**From:** Pinna-Morrell, Gillian  
**Sent:** 08 September 2025 13:59  
**To:** \_planningadvice  
**Subject:** General Enquiry

Hi, could you please attach the comments below to application H02-0575-25 as Conservation Officer comments with the code 2STAND, thanks.

**Gregory Watkinson BA (Hons), MA**  
Principal Conservation Officer  
South & East Lincolnshire Councils Partnership

S105 & S202 S - 01 - Elevations 1:100 @A3 Rev: A

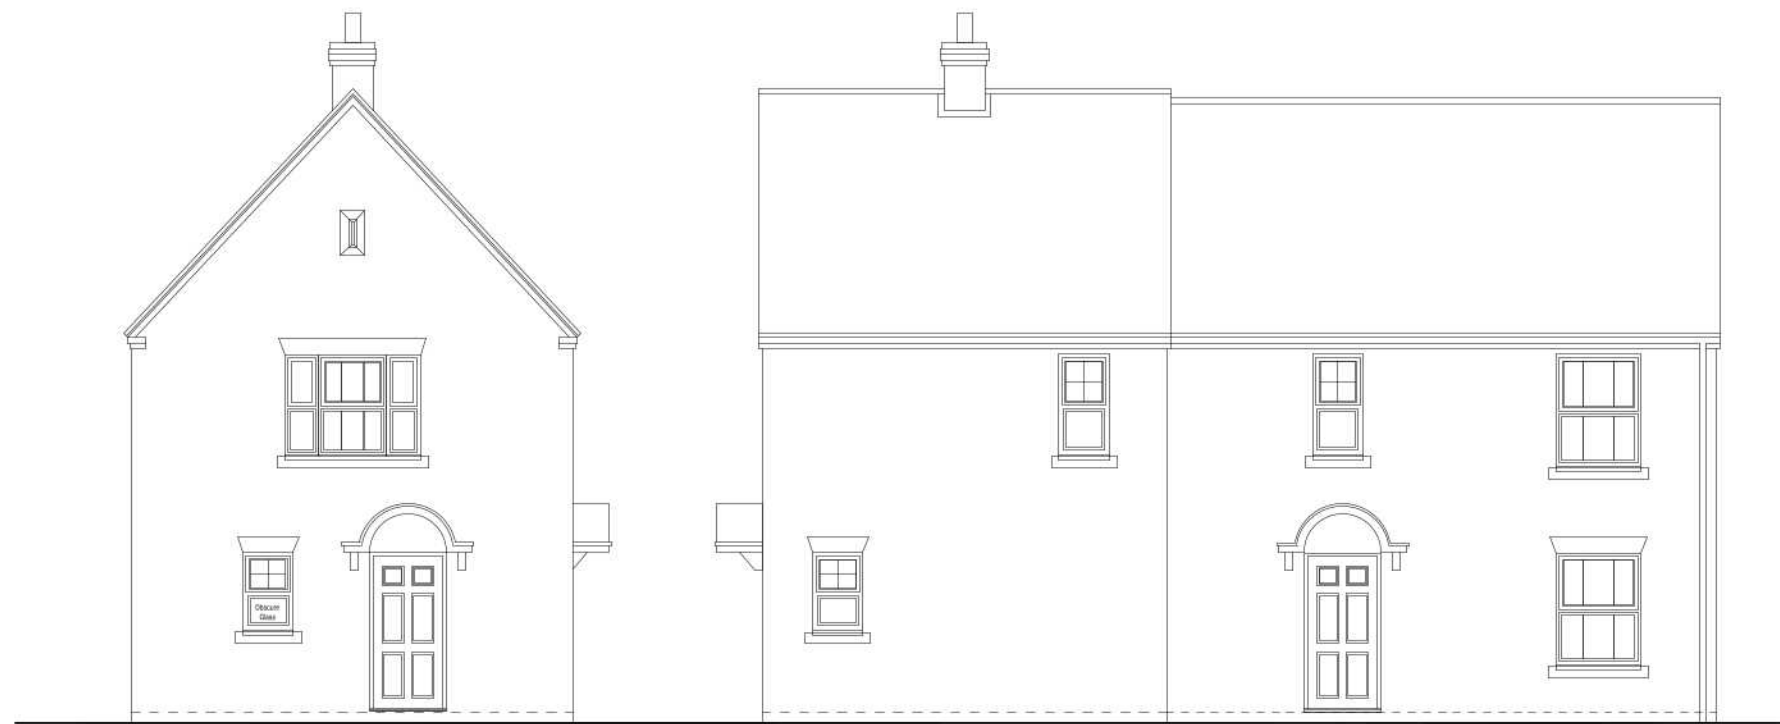
However, I have noted that the applicant intends to utilise some non-vernacular materials, particularly in the roofing material for which the applicant proposes concrete mock slates. Per Policy 29b(4) of the SELLP, I would suggest that materials such as concrete mock slates are not appropriate to the vernacular in terms of material. I would therefore request that the applicant be required to amend the proposed roofing material to a natural slate alternative. It should be noted that this would appear to be the material that was required and installed for the directly adjacent, and notably similar development on Benedictine Square. If the applicant is unable to commit to this amendment at this time, then I would suggest that this could be ensured by means of a condition requesting full details of external materials prior to commencement, that notes the need for natural materials within a central, conservation area setting.

In view of the above, if the application is to be approved, I would similarly recommend that conditions requiring that the detail of windows, doors, rooflights, domestic accoutrements and landscaping should be submitted to and approved in writing by the LPA should be applied. Moreover, to reinforce the need for appropriate treatment with materials, I would also suggest the imposition of SHDC standard conditions MD14 & MD42 should be applied to ensure that windows are white painted timber and rainwater goods are black painted metal. Finally, with the imposition of the condition for details of roof lights, a note should be added that an expectation would be that these would be of a conservation style. All of these conditions are considered reasonable measures to enforce under the authority of Policy 29 of the SELLP.
